AECOM
NORTH BRIERLEY, BRADFORD

STAGE 1 ROAD SAFETY AUDIT

JANUARY 2018

Project Code:	LKLEASINGWOLD2.6
Prepared by:	Geoff Blackburn
Approved by:	Martyn Parr
Issue Date:	JANUARY 2018
Status:	DRAFT

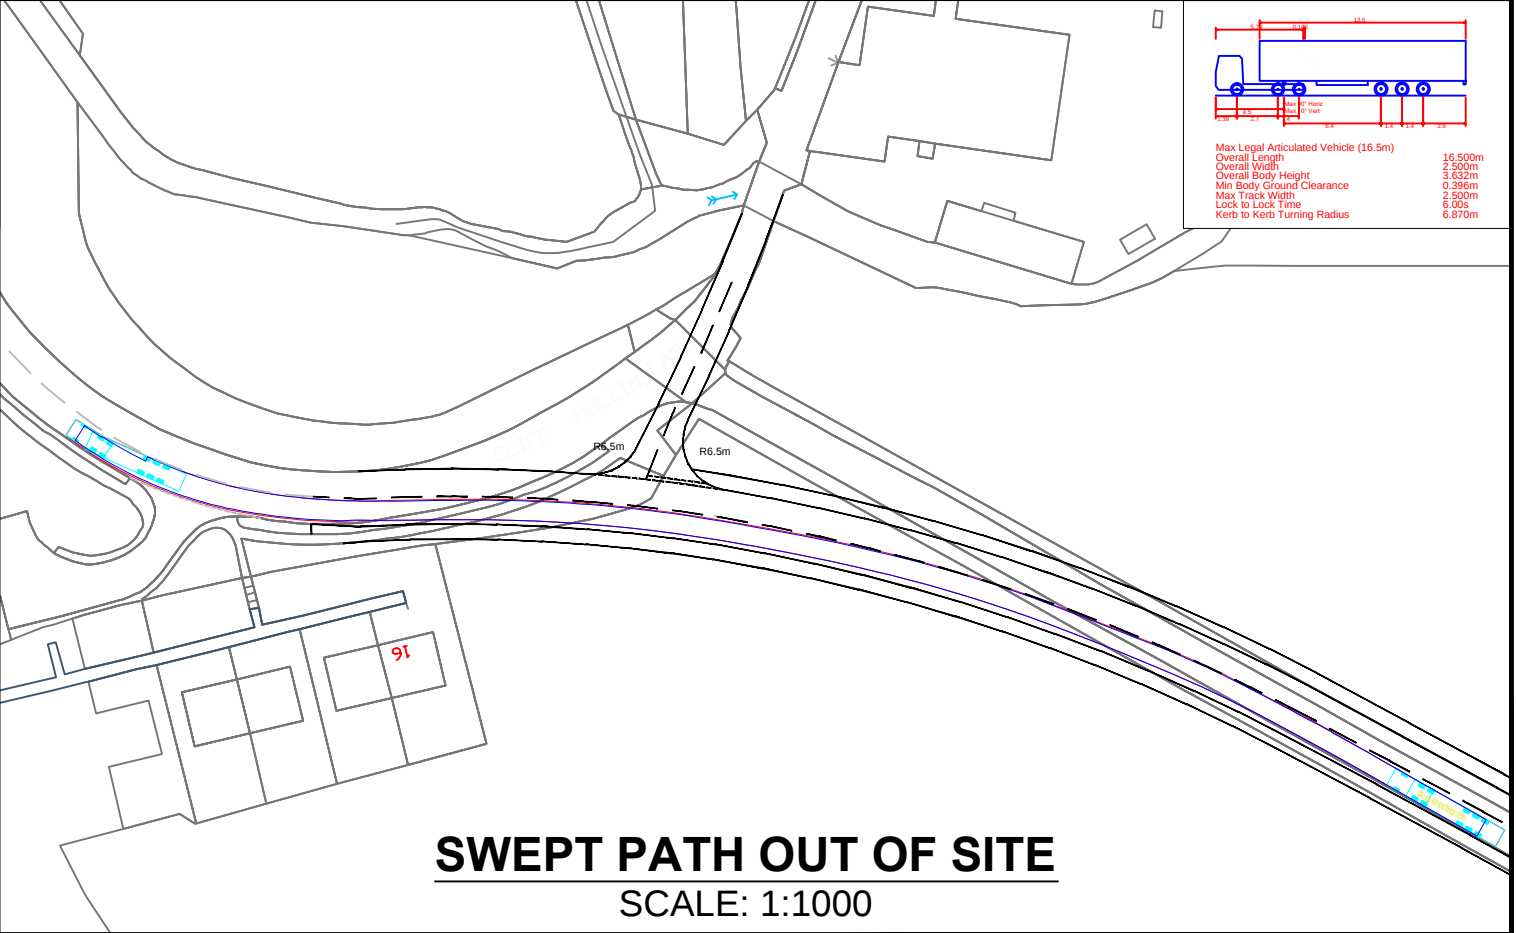
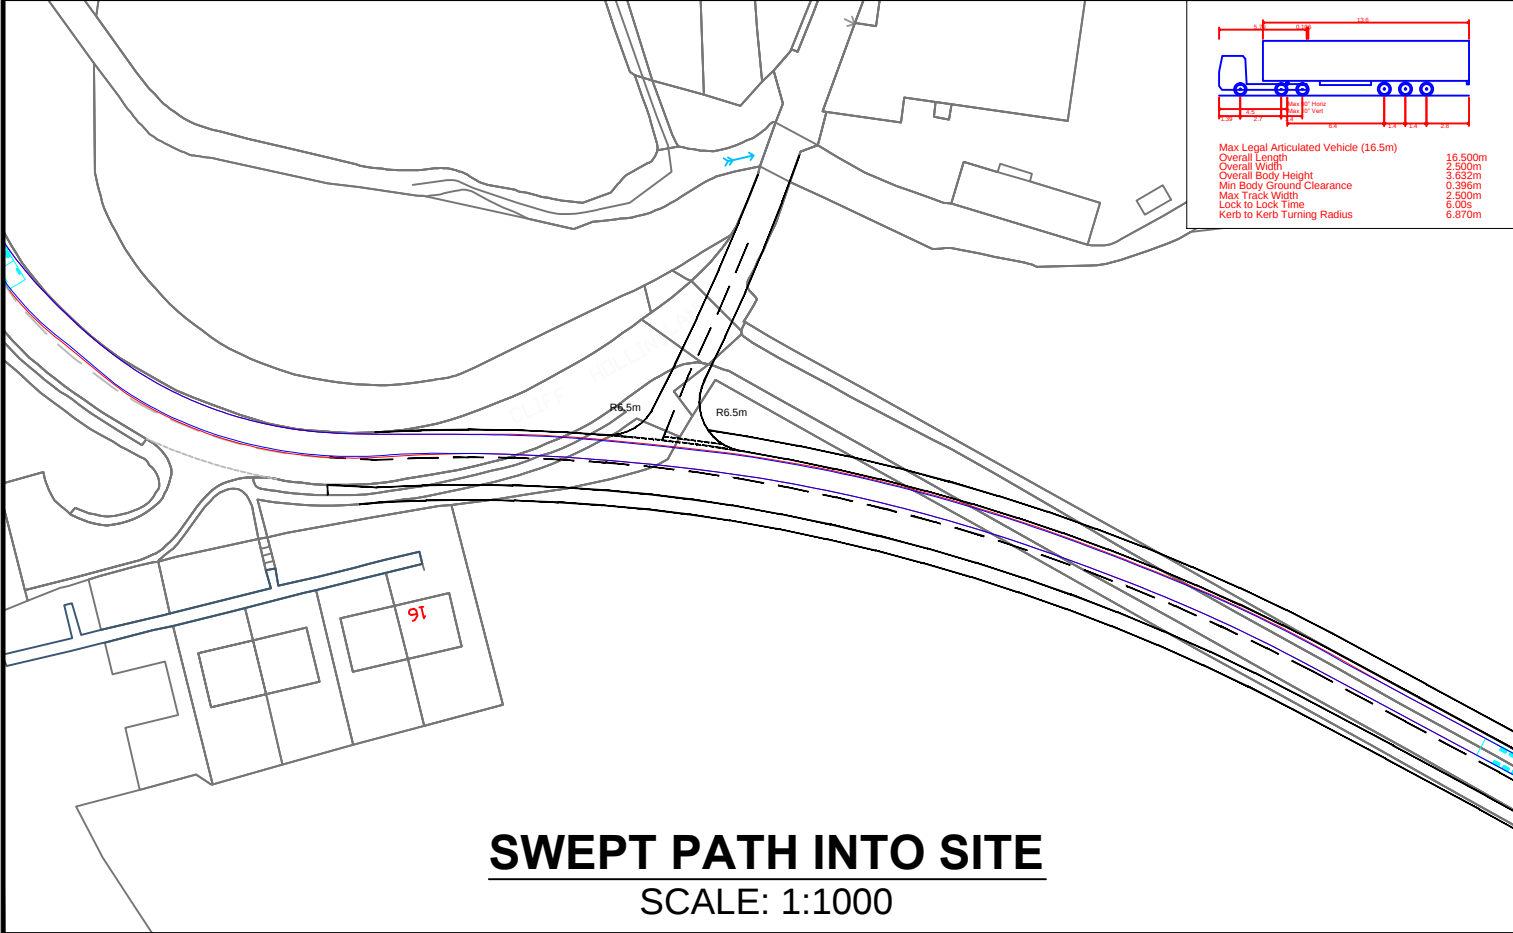
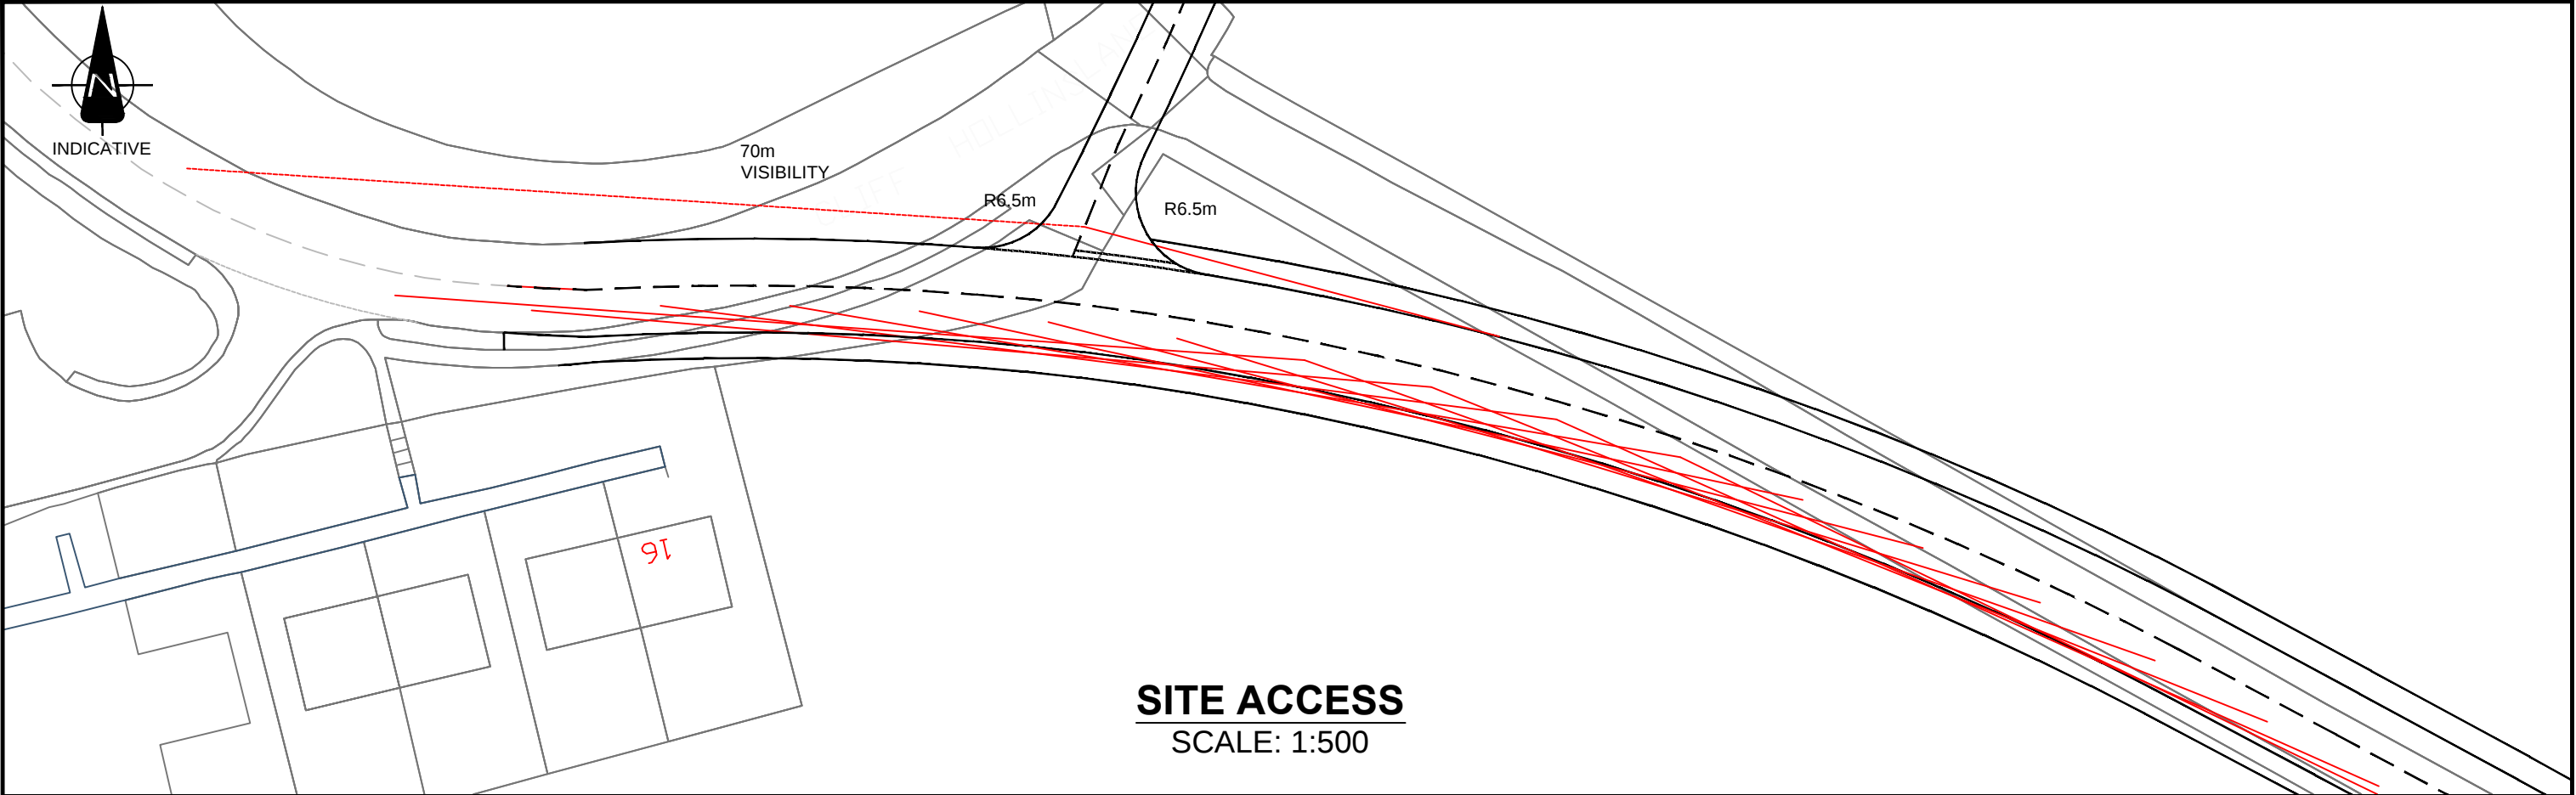
The proposals show separate left and right turning lanes out of Mill Carr Hill, however, based on the track plots provided, these appear narrow with some encroachment of large vehicles onto adjacent lanes.

This creates a risk of conflict between a large vehicle and any vehicle in an adjacent lane which in turn creates a risk of collision and possible injury.

The designer has provided track plots show 16.5m articulated vehicles along Mill Carr Hill Road which is welcomed.

However, these plots do not show the turning movements at the proposed Mill Carr Hill / Bradford Road junction. Failure to produce adequate AutoTrack plots of all turning movements could result in large vehicles encroaching on lanes used by oncoming traffic.

This could result in conflict which in turn could result in collision and possible injury.

The lane widths and track plots should be revised to avoid encroachment on adjacent lanes.

Full track plots should be provided and the design amended as necessary.
